PEER REVIEW STATEMENT - ADDENDUM

ATTENTION:	Mr Paul Freeman, NSW Dept of Planning Infrastructure and Environment	
FROM:	Hugh Middlemis, Principal Groundwater Engineer, Hydrogeologic Pty Ltd	
REFERENCES:	13 Sept 2019	DPIE ref: Vickery Extension Project Groundwater Assessment
	HGL job#: 61.073	
SUBJECT:	Vickery Extension Project groundwater assessment peer review - ADDENDUM

**Figure 2** Simulated Water Table (mAHD) at the end of Vickery Mining (Stress Period 111) for Fully Backfilled Void

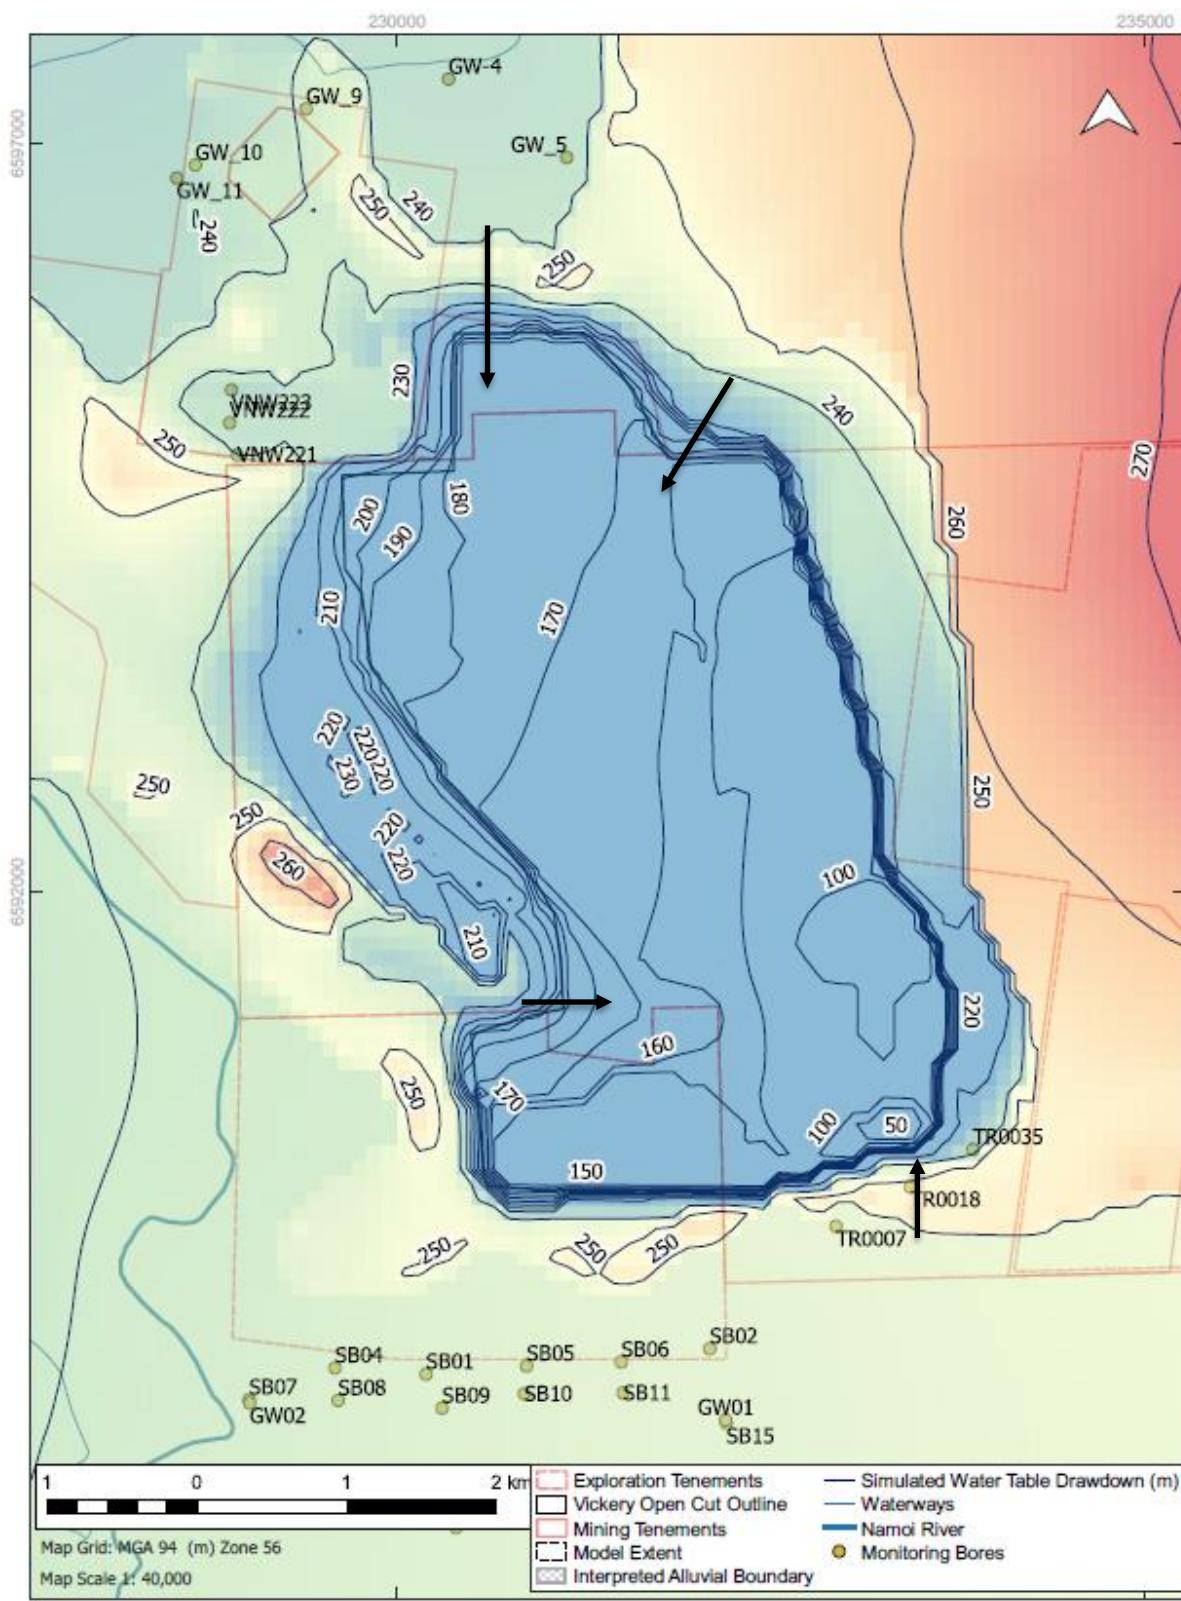
The backfilled final pit scenario applies a recharge rate to the waste rock emplacements of 5%, and a 1% case is also presented. The recharge rates are high and perhaps questionable in relation to the calibrated recharge rate to the alluvium of about 1%. Other options are available for waste emplacement that may limit the recharge rate (e.g. capping with low permeability material), which would reduce the mounding and consequent seepage rates, but this has not been reported.

The effect of the relatively high recharge rate to the waste rock emplacements appears to result in a groundwater mound centred on the backfilled pit. This results in what is described as low quality seepage through the backfilled pits, although geochemical analysis has not been reported.

Unless and until a geochemical analysis is completed, it cannot be known whether the ‘low quality’ groundwater seepage from the partially or completely backfilled pits (i.e. the final void or backfilled pit options, respectively) may be problematic in terms of its transport and fate to final discharge to the environment and interaction with any ecological receptors. For the completely backfilled pit, the groundwater flow pattern is radially outwards, towards the Namoi River alluvium, and into the low permeability Maules Creek Formation. It should be remembered that this is a high recharge backfill case, and it is not known what the flow pattern might be with a different (optimal?) final landform (see also next section). For the proposed final void option, it has been clearly shown to act as a long term sink, with seepage inputs to the final void lake from the surrounding partially backfilled mined voids, but with no potential for groundwater outflow. However, there is no geochemical assessment of its water quality, other than salinity, nor assessment of what potential beneficial uses (or otherwise) could be invoked.

It is recommended that consideration be given to devising suitable project approval conditions that would require the iterative integration of mine planning with groundwater modelling to investigate final landform scenarios and identify the optimal balanced solution that that
